**Harnett County**  
420 McKinney Pkwy  
LILLINGTON, NC 27546  
Phone:  
Fax:

**SUBJECT: SFD2310-0022**  
**SINGLE FAMILY DWELLING**

Here are the results of all Inspections located at **188 HOBBY RD:**

FLOOR PLAN
SCALE: 1" = 1/4"

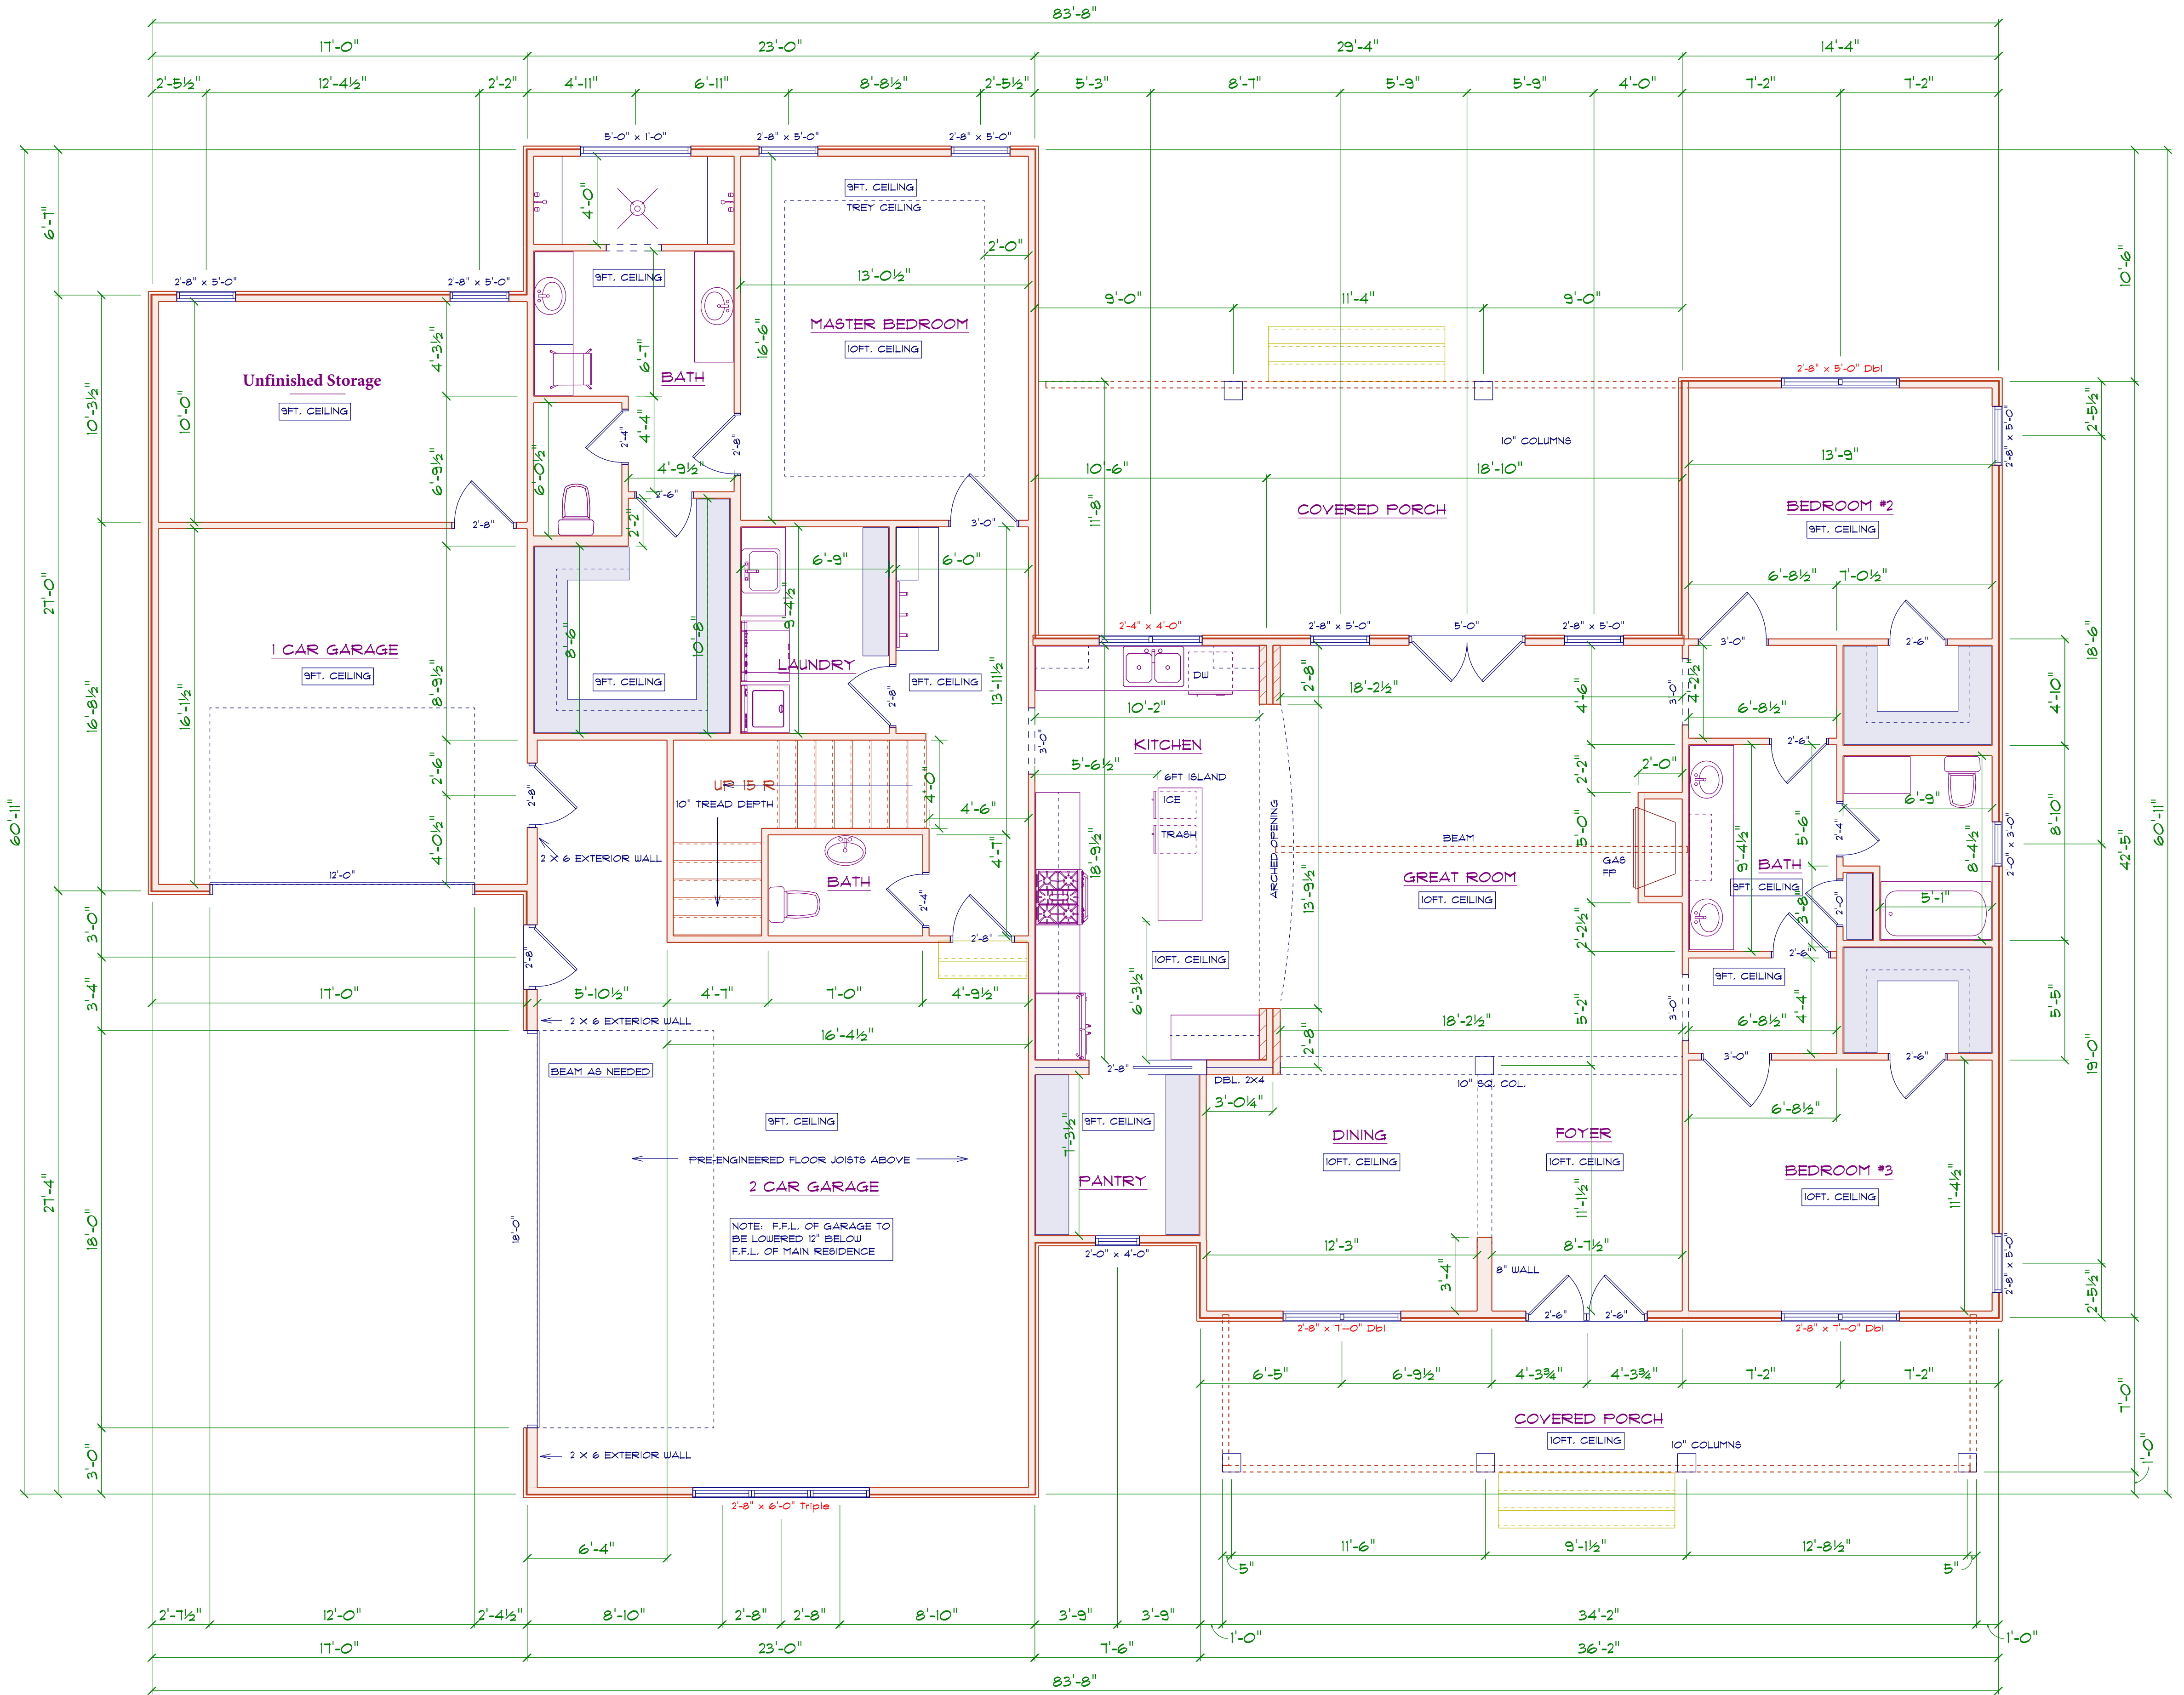
1. Lvl's at foyer area need nailing together per manufacturer. 2. Need letter for cut lvl at post in foyer area. 3. Rafter support wall cannot bear on ceiling joists without engineer. 4. Rafter support walls with single top plate must have stud under each rafter. 5. Air barrier and insulation under both seats in left rear shower. 6. Add kings to left rear shower header per length. 7. Air barrier upstairs walls to short. 8. The 7th 2x10 ceiling joist from right to left above family room is cracked seen from attic area. 9. Brace rafter support walls per code. 10. Stud shoes required on load bearing bored studs for plumbing drains behind fireplace. And at left rear bath. 11. Water lines and p trap in garage ceiling may need insulating pending how r19 insulation is installed later. 12. Both garage headers incorrect per layout that was uploaded to permit. 13. Install and tape house wrap per manufacturer instructions multiple places also check window tape around windows (right rear window peeling off in top corners). 14. 2x2 square washers at portal framing anchors. 15. Need hvac duct boots installed and sealed. 16. Each side of front porch rafters bearing on osb.

Do not see engineer letter for cut lvl at foyer post. Ok to insulate.

Inspection Type: ROUGH IN REINSPECT  
Scheduled Date/Time: 4/24/2024  
Completed Date/Time: 4/24/2024  
Inspector: Justin Ryan McLeod  
Result: DISAPPROVED  
Remarks: eTRAKiT Inspection Request  
Notes: Same from last inspection, need engineer letter for cut/notched lvl at dining room.

4/16/2024 2:51 PM HARRINGTON PROPERTIES OF NC  
-Duct Boots are installed at trim out by our HVAC company and we do a duct leakage test  
-The air barrier under the master shower will be done by our insulation team and can be seen on insulation inspection. We have attached requested letters and new beam calc sheets. Thank you!  
Contact Name: HARRINGTON PROPERTIES OF NC  
Site Address: 188 HOBBY RD  
Phone: 9197705969  
e-Mail: BRANDON@HARRINGTONPROPERTIESOFNC.COM

Per email another full length lvl was added. I Can only see the end of the beam that was added. Builders responsibility for the if it was full length beam as the email stated.
